Client E. DALTON	
Project Leather Hall Barn, Honley.	
Drawing Proposed redevelopment of existing stable to form granny flat ; Location Plan Planning Application	
Number 4378-00-01c	Checked Scale @ A3 As Marked
Date 02/2021

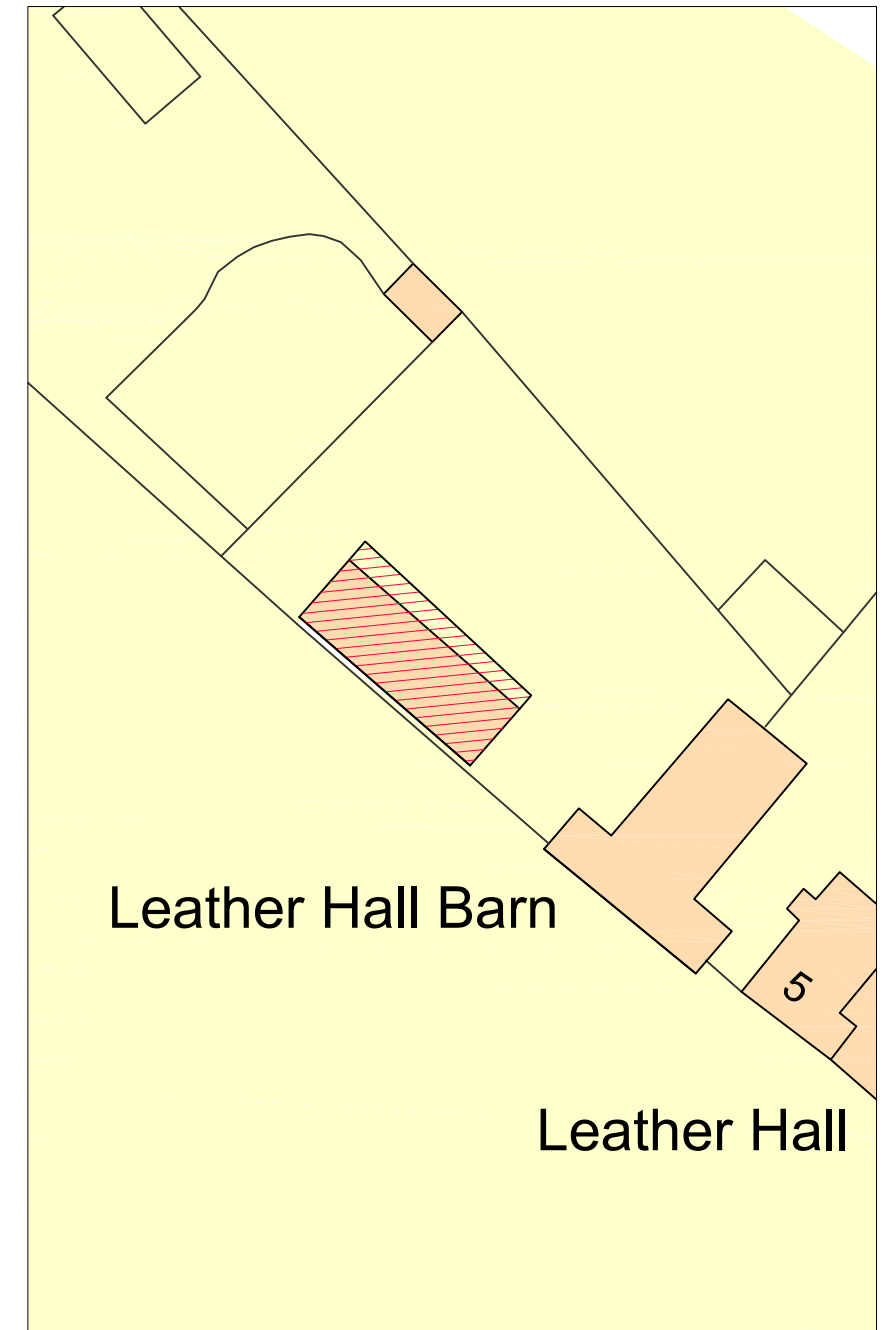
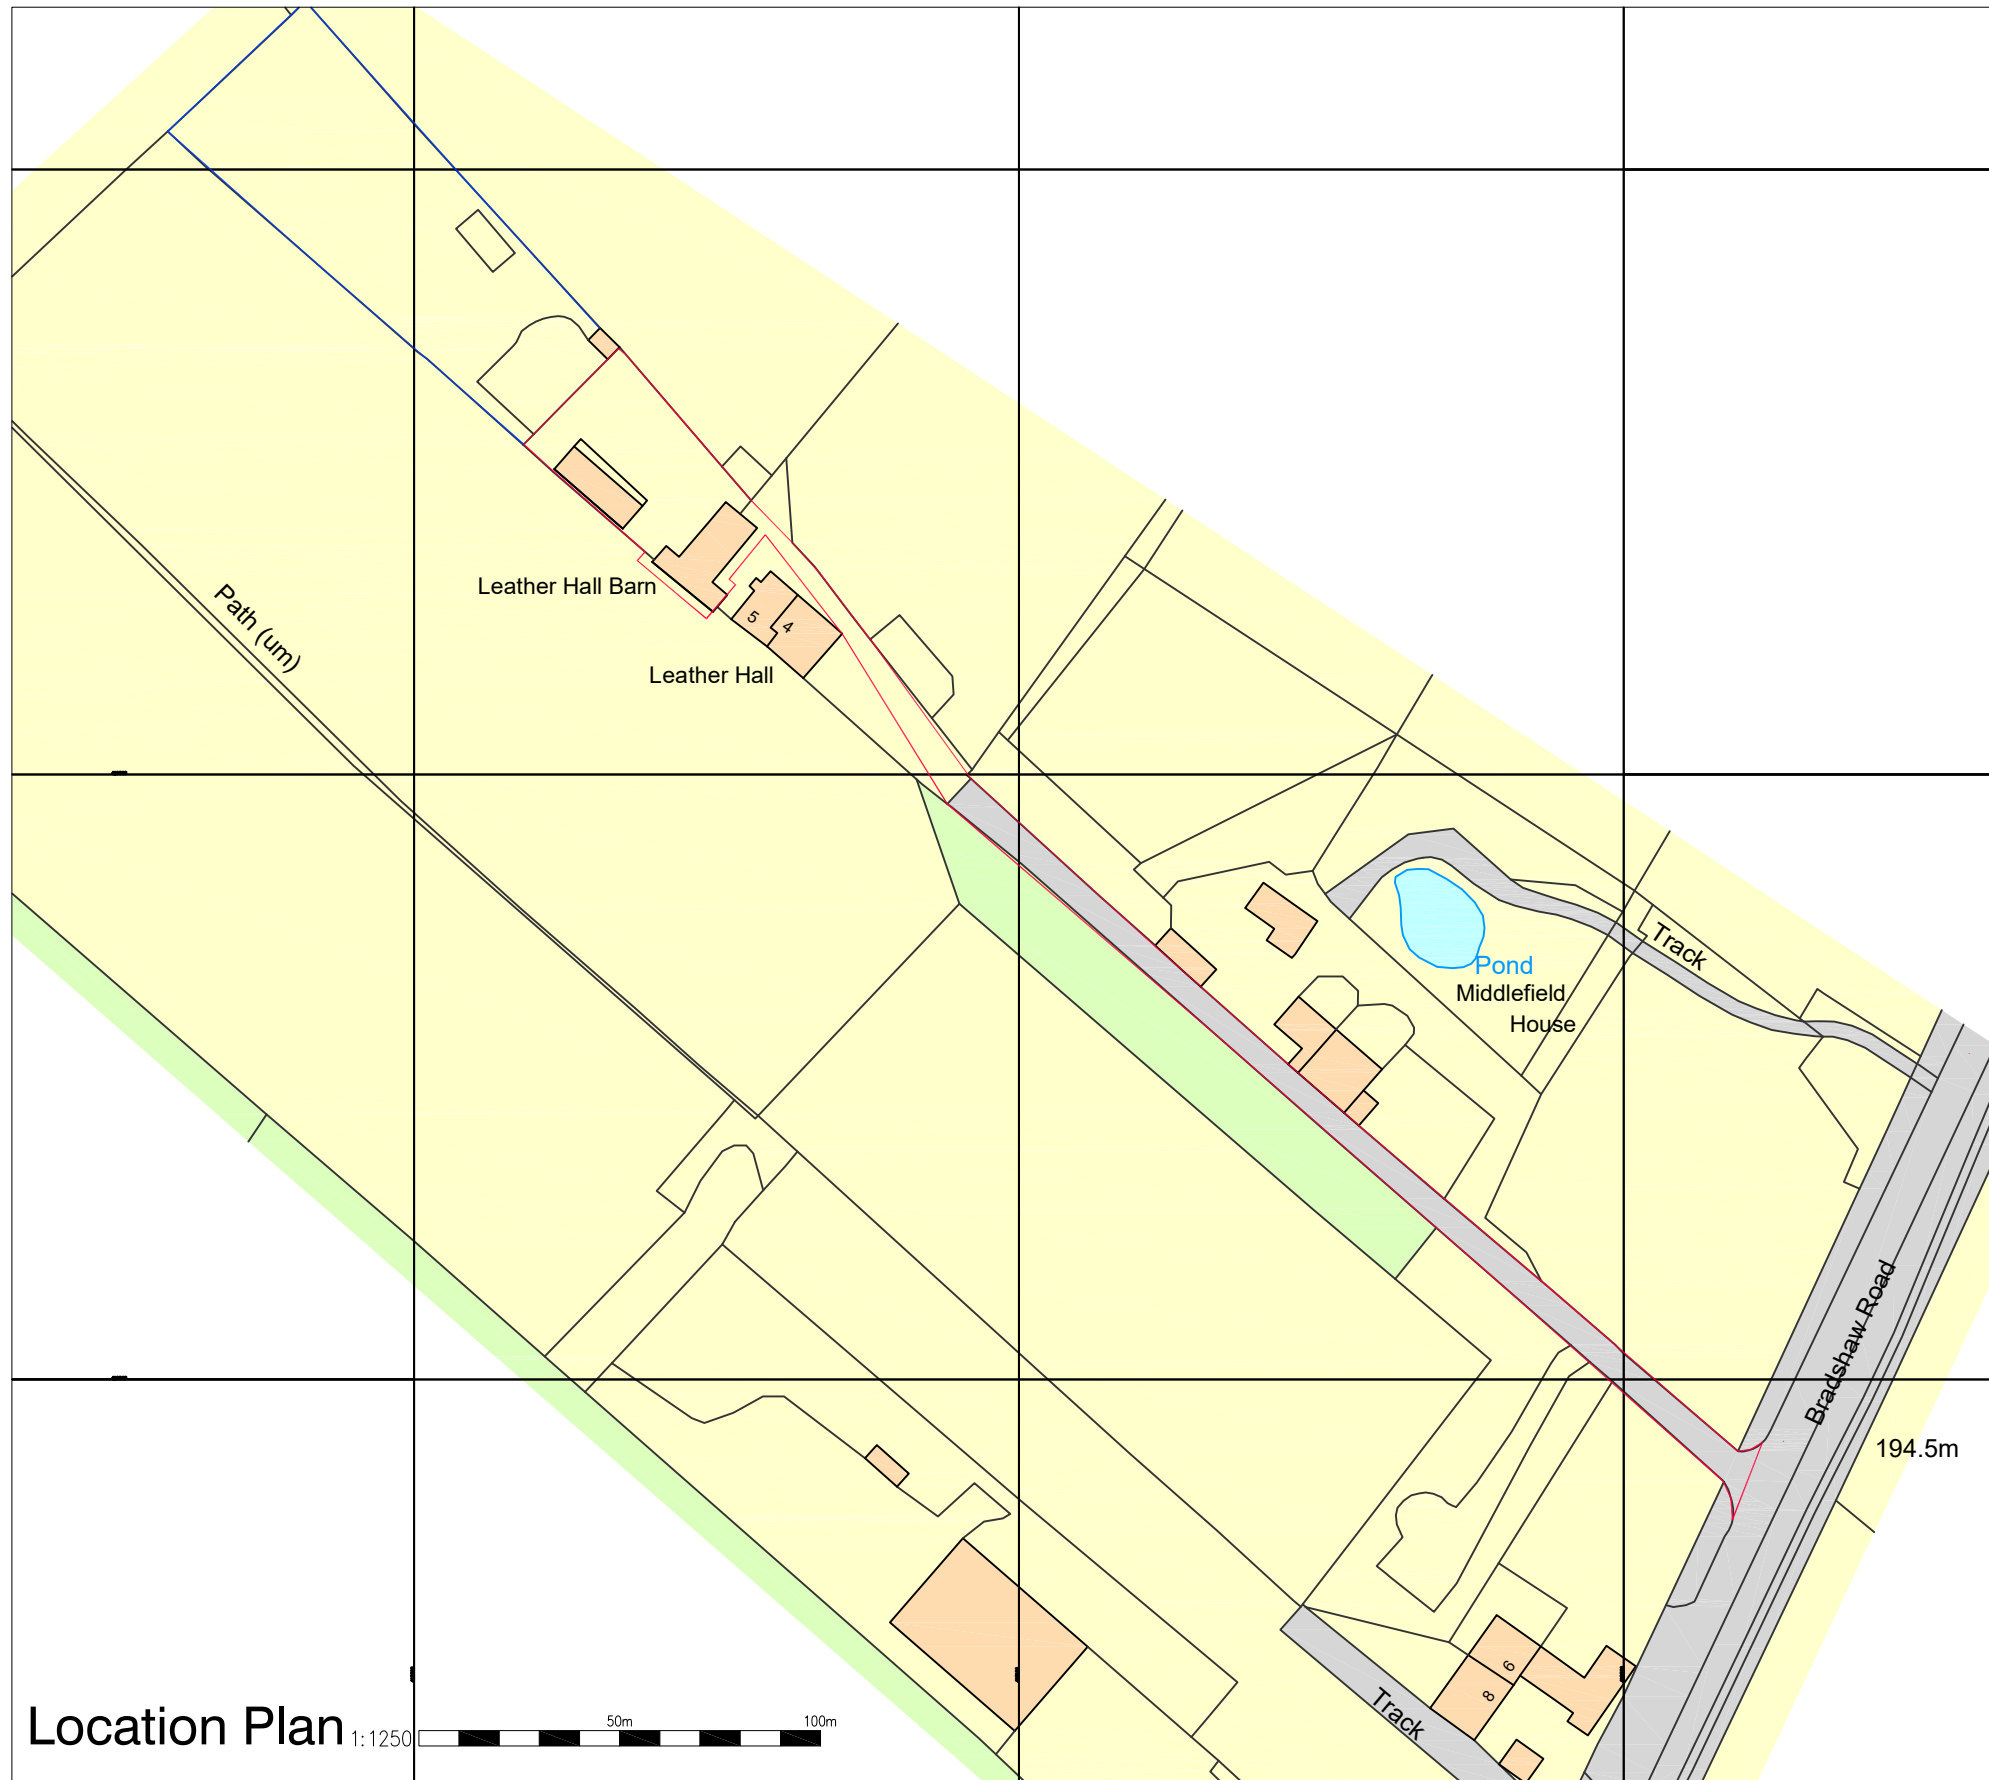
It is also noted from the Location Plan that the red line boundary extends beyond the existing stables. However, when the main house was granted planning permission for its conversion from a barn to a new dwelling in 1998 (LPA ref: 98/92544), the red line boundary, and therefore the residential curtilage, only extended just beyond the main house and did not include the stables or the adjacent land.

Despite historical Google Earth images appearing to show that the land in question has been unofficially domesticated over the years since the barn conversion, it is considered that this land should not be included within the red line boundary of this application, unless the applicant is proposing a lawful change of use of this land to extend their domestic curtilage as part of the proposals.

In addition, the applicant also owns the land directly north-west of the application site, edged in blue on the Location Plan. If approval is given for an extension to the original domestic curtilage, what is stopping the applicant from encroaching into this area of land in the future causing even further harm to openness? ² Again, it would appear from current Google Earth images (see below) that an area of hardstanding has already been constructed on this land without planning permission.

In addition, as discussed above, it is considered that the change of use of land to extend the residential curtilage should also form part of the description if the area of land in question is to be included within the red line boundary.

Client E. DALTON		
Project Leather Hall Barn, Honley.		
Drawing Site Survey : Proposed redevelopment of existing stable to form granny flat		
Number <b>4378-01-01b</b>	Checked Scale @ A1 1:100	Date 02/2021

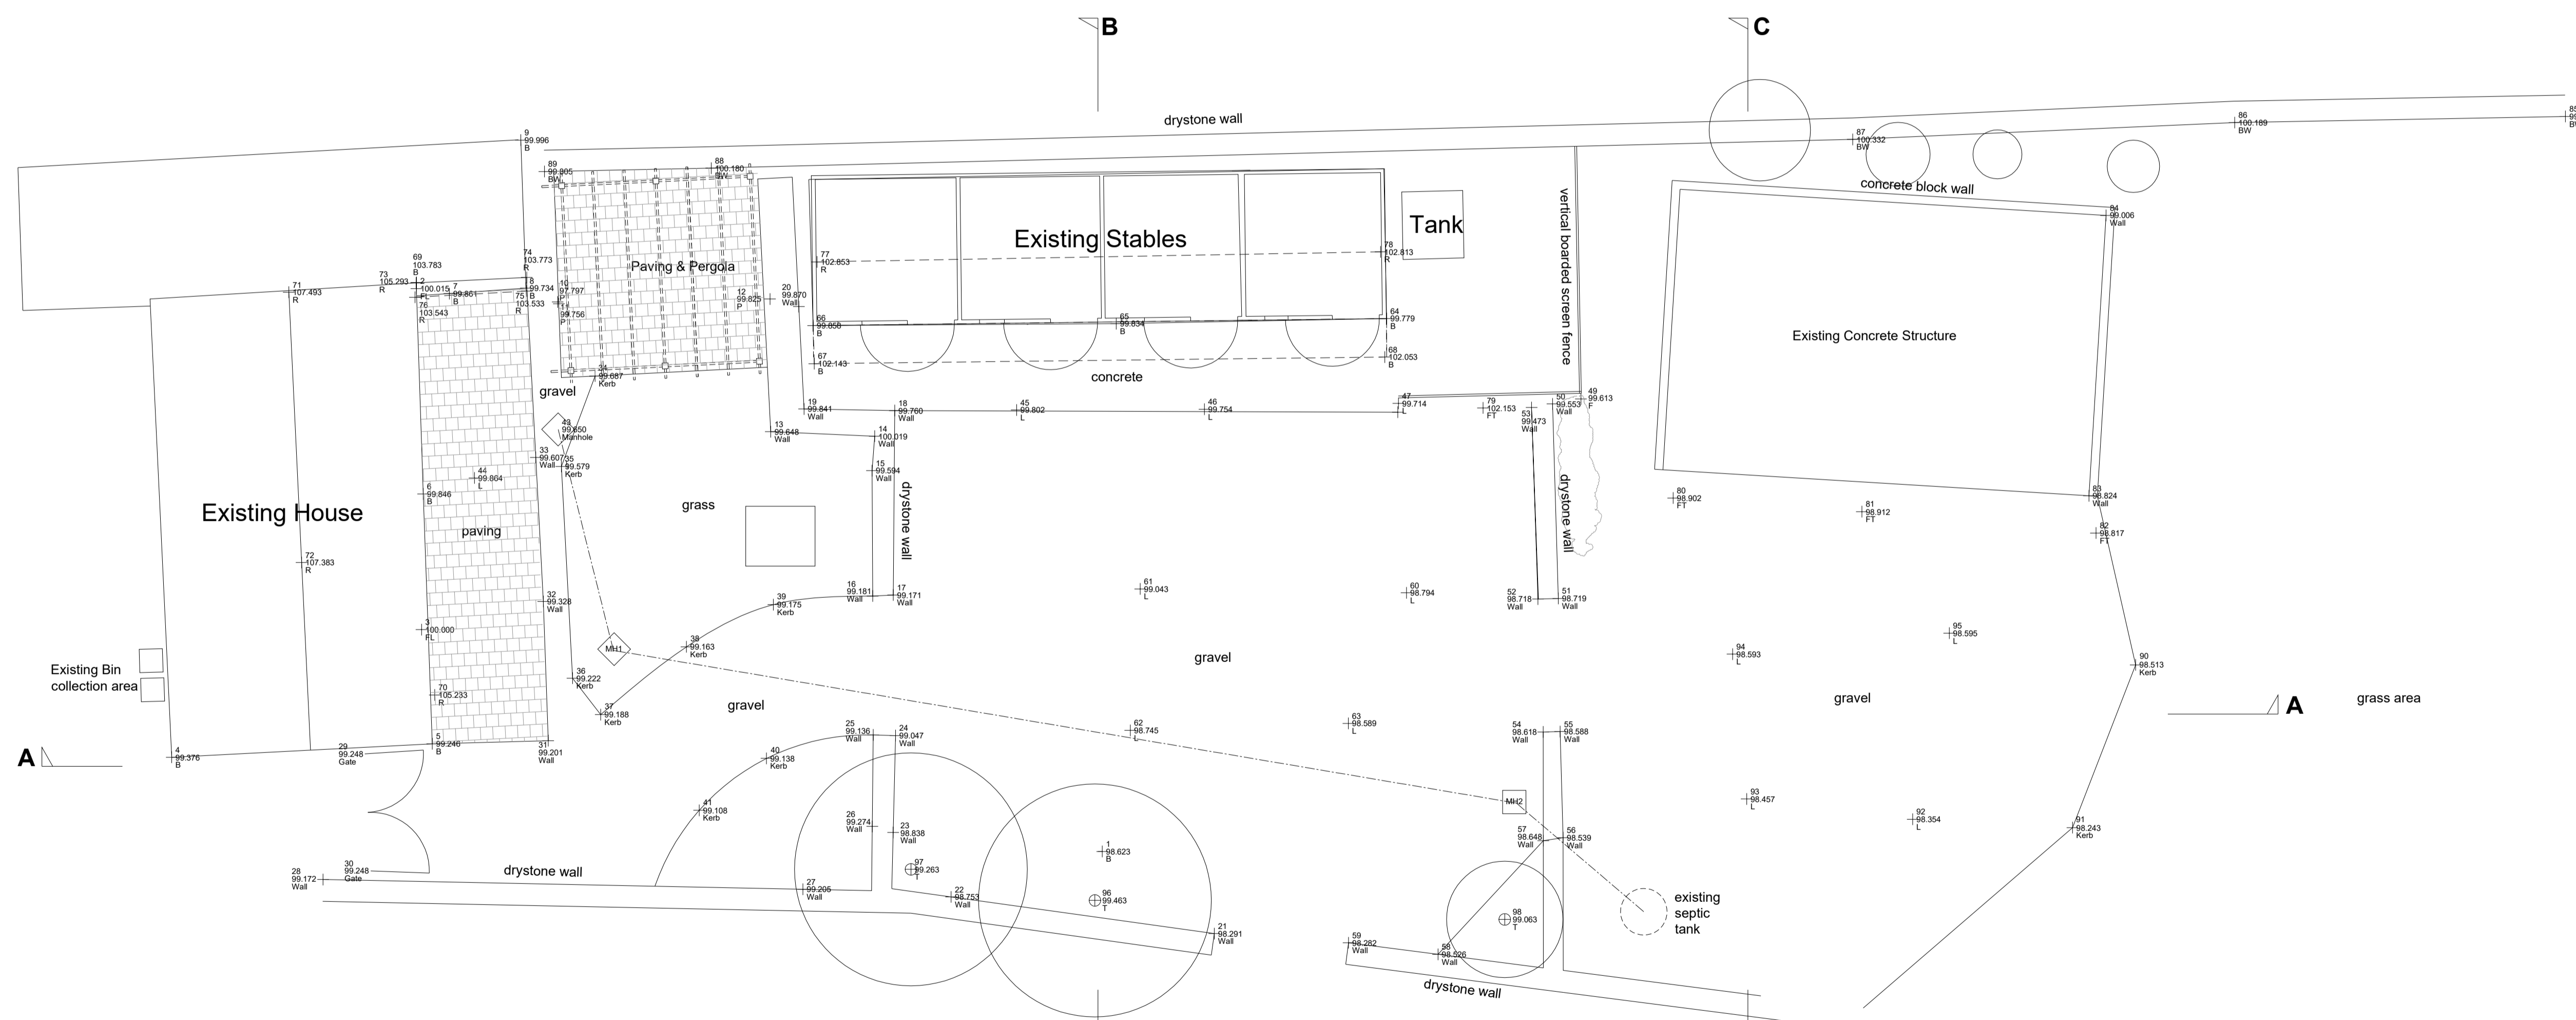
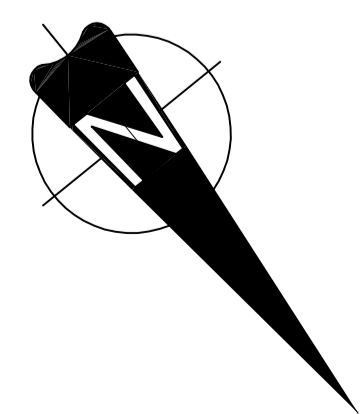
3.8m giving a footprint of 56m². By contrast the floor area of the proposed annex measures approximately 15m x 6.0m giving a footprint of 90m². This is an increase of 34m². The footprint of the proposed development therefore exceeds the footprint of the existing development, which is contrary to Policy LP59. Furthermore, the height of the building proposed would be increased from 3.1m to 3.5m. This, along with the increase in footprint, would result in a building with a much greater volume than the existing.
